# Rezoning Transportation Analysis

Petition Number: Insert Zoning Petition #2022-048

Date	Description
08-25-22	First Review (PDM)

STREET SECTION A-A

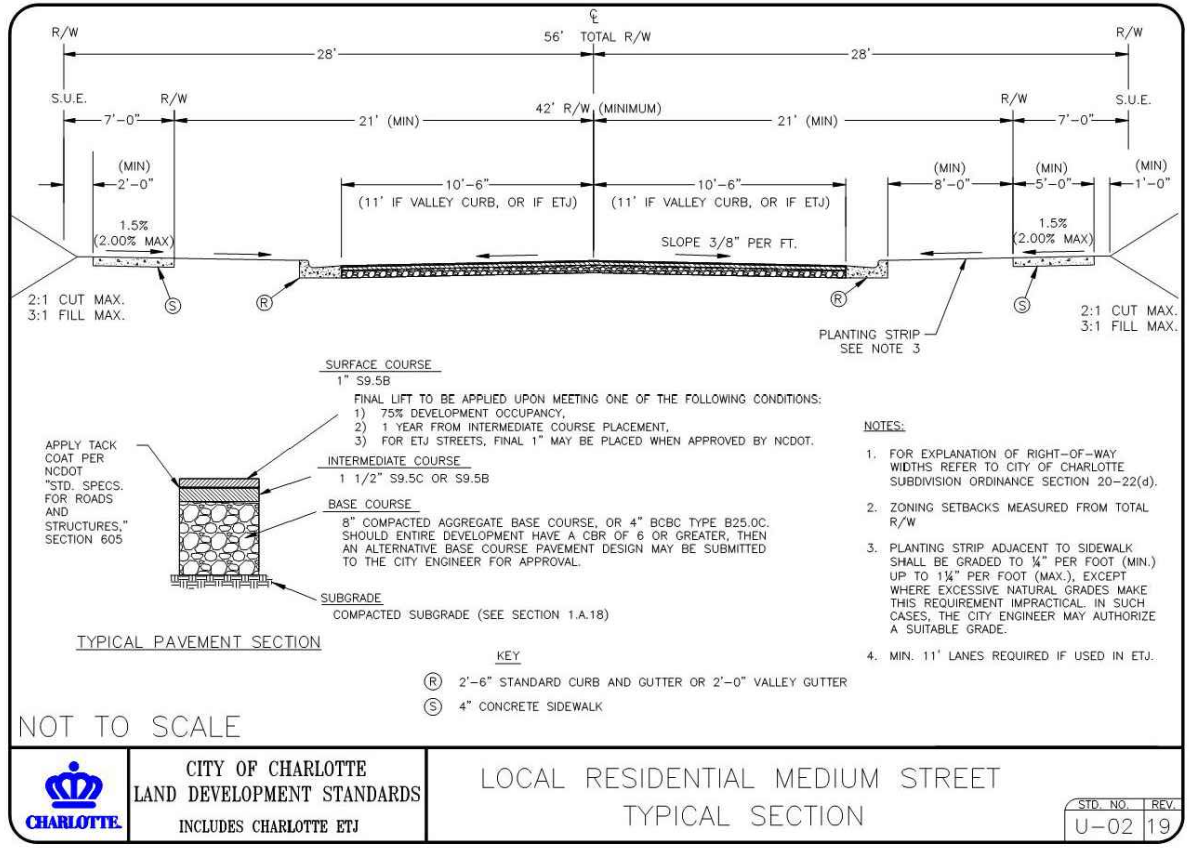
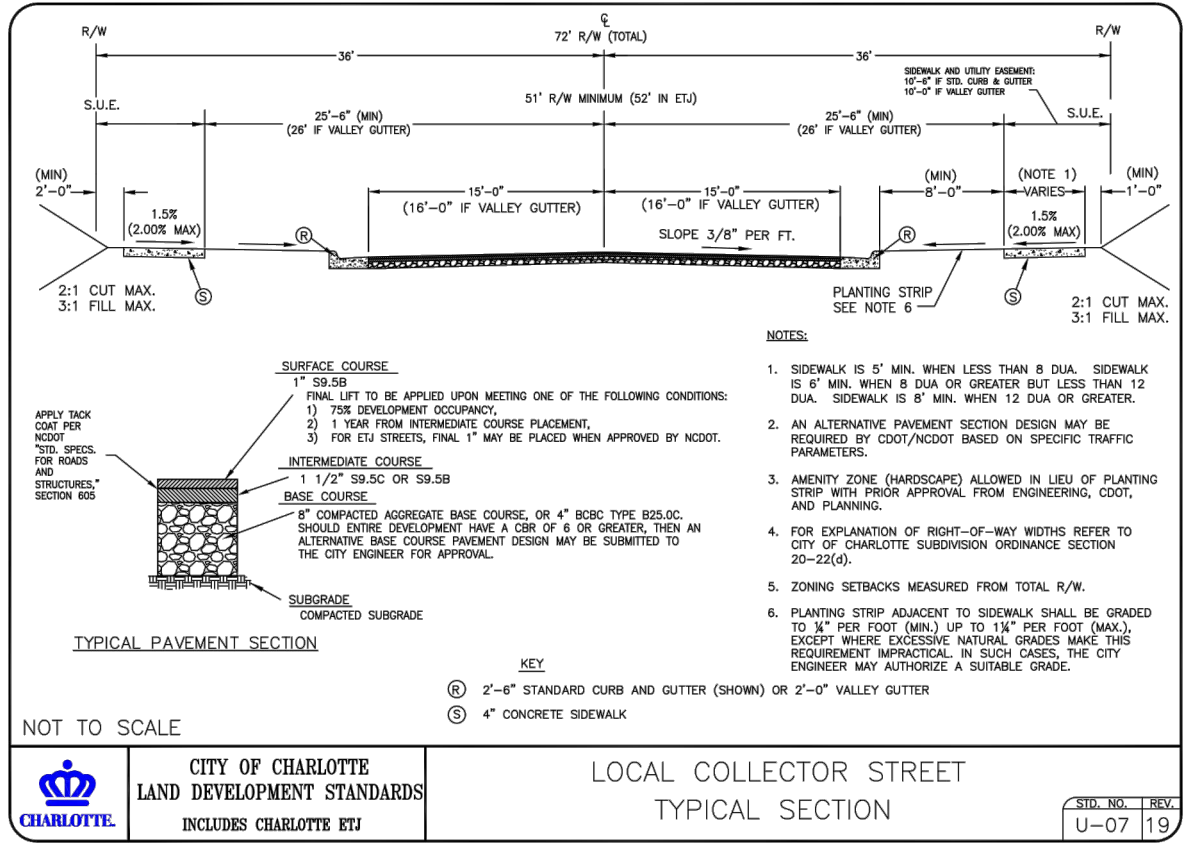
3. Revise site plan and conditional note(s) to commit to the proposed roadway network typical sections and proposed phasing outlined in the Traffic Impact Study. Provide typical sections per CLDSM for all proposed public and private streets. Provide 8-foot sidewalk and 8-foot planting strip on all public streets.

RZ-2

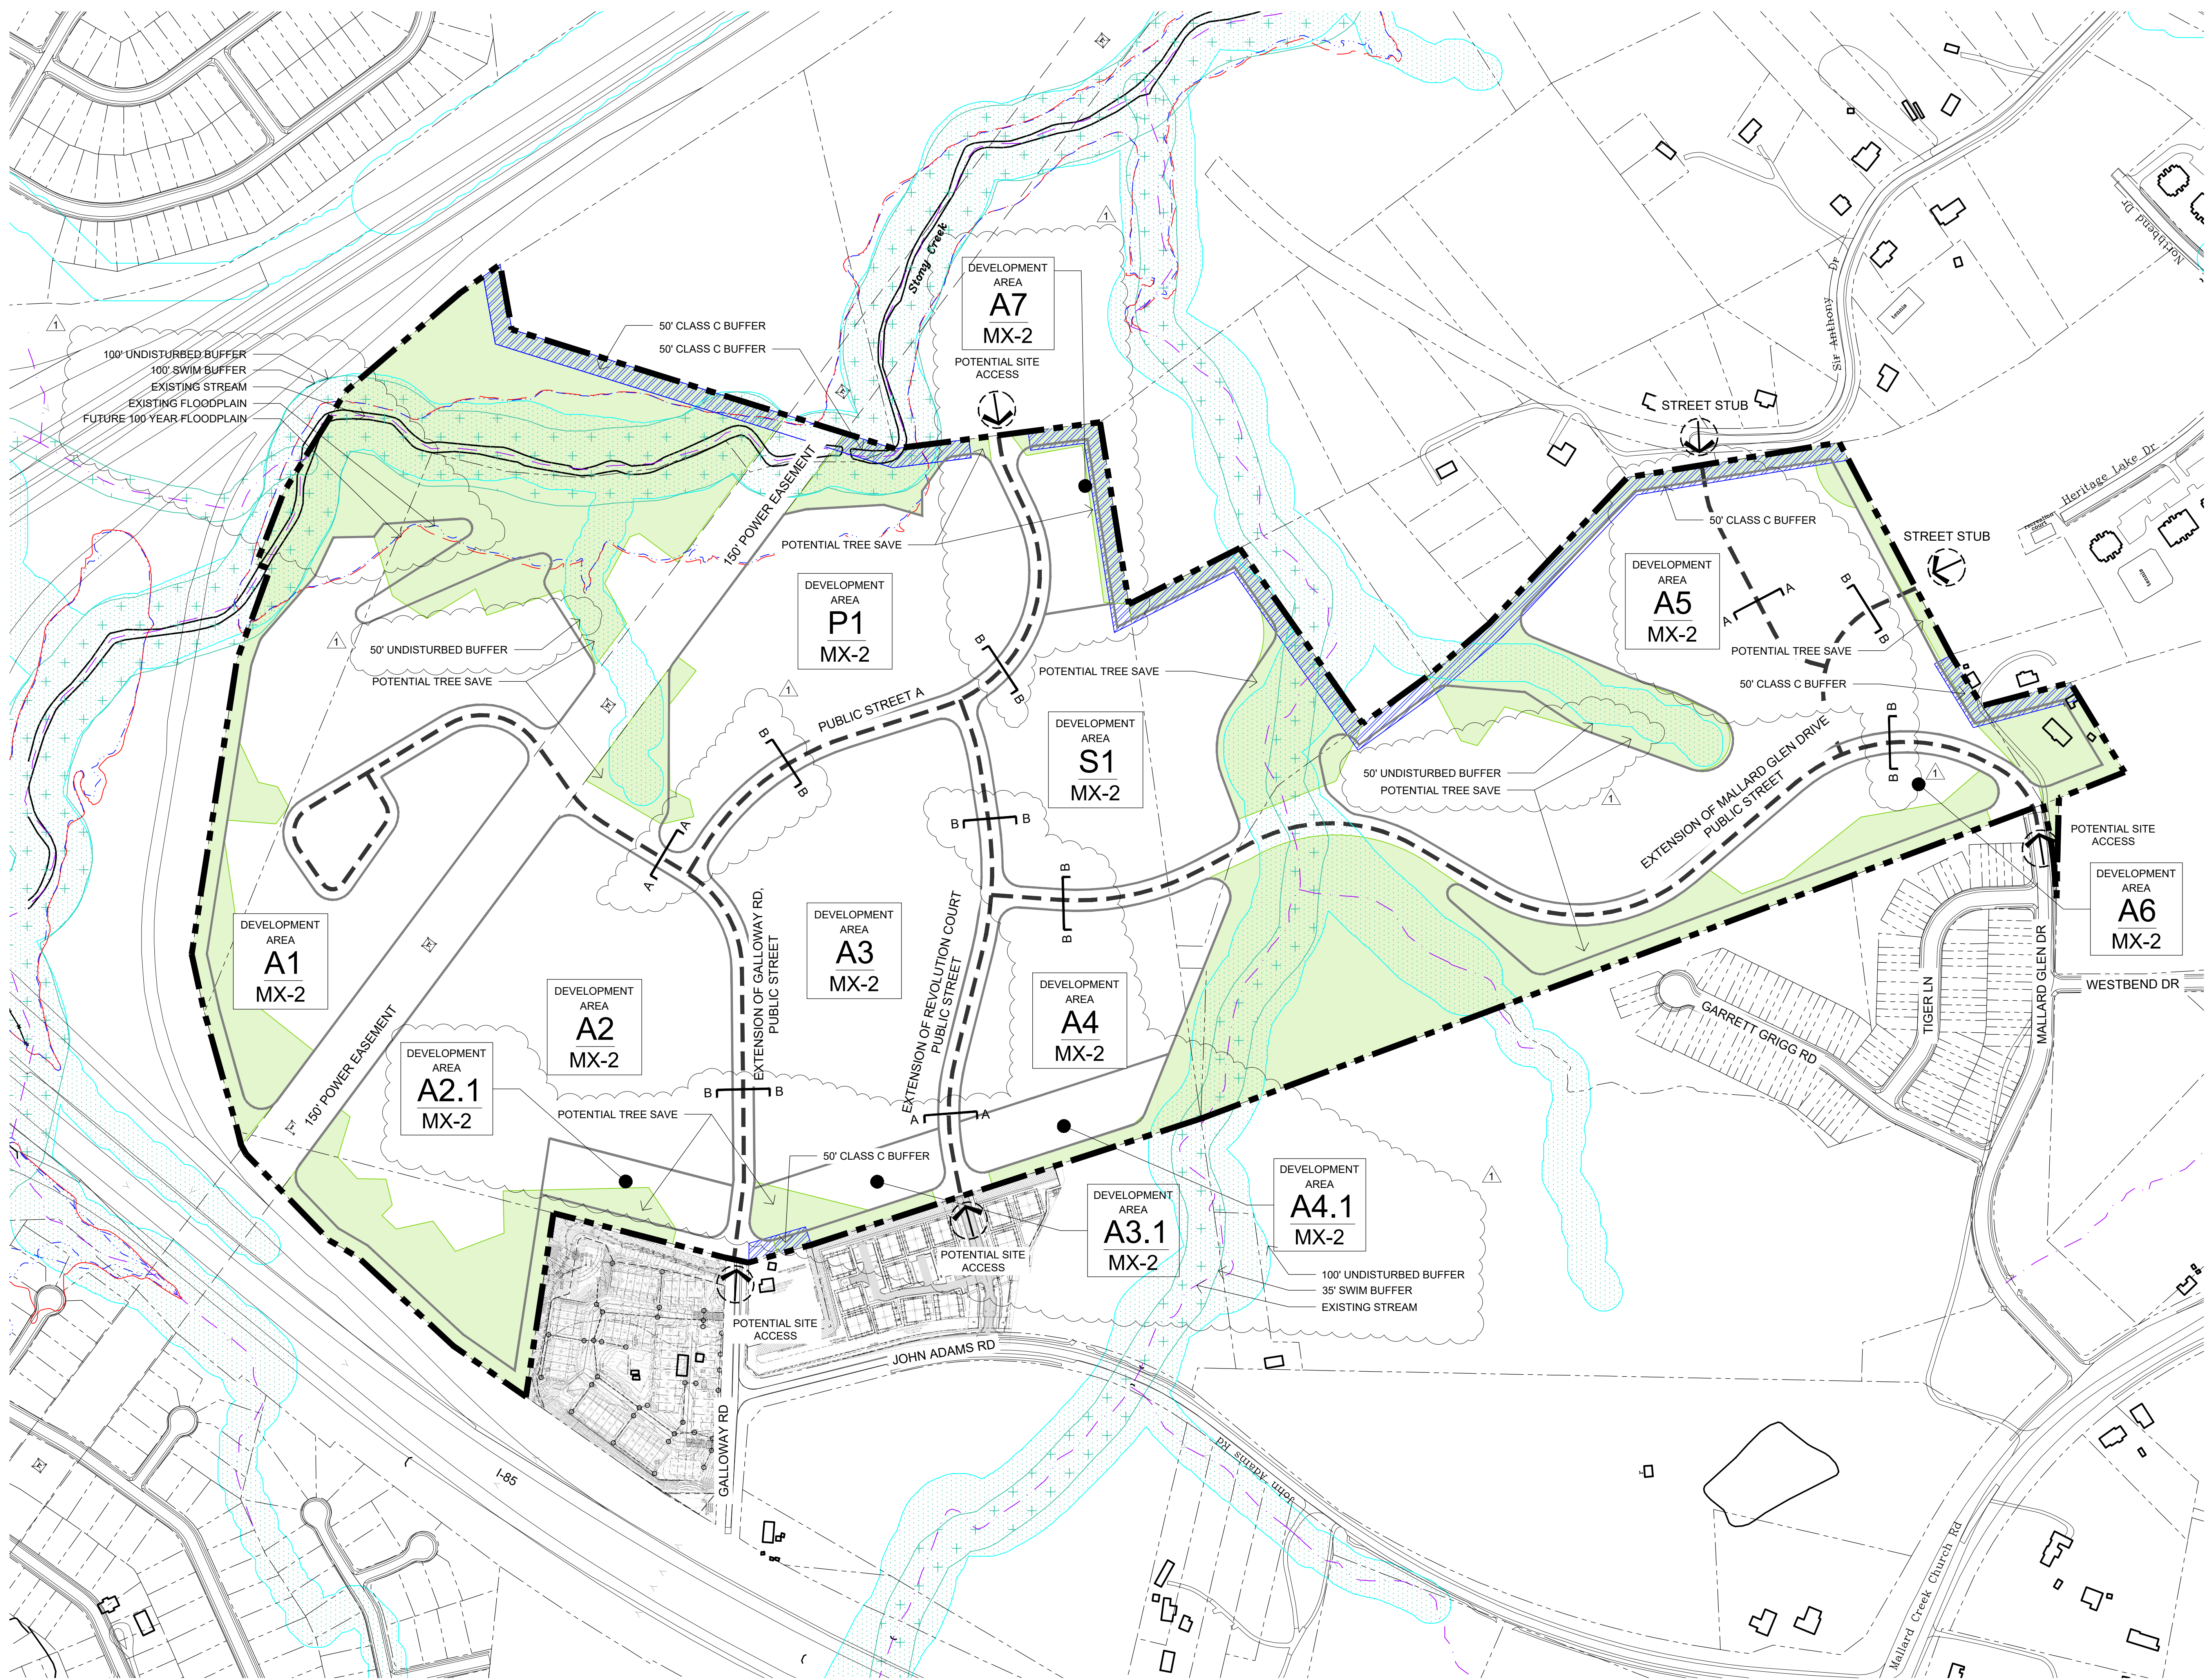
### 2. Revise site plan and conditional note(s) to commit to improving Galloway Road to the local collector street typical section per U-07.

RZ-3

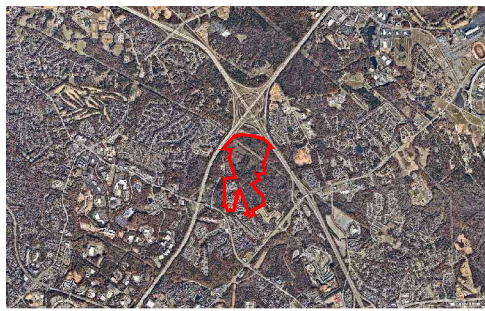
4. Add conditional Lighting Note for petitioner to coordinate with CDOT Lighting, Bruce Horltd (704-589-5836 or Bruce.Horltd@charlottenc.gov), prior to permitting of lighting fixtures on public roadways.
5. **CDOT RECOMMENDATION:** CDOT recommends the petitioner commit to providing a public street connection to Sir Anthony Drive.
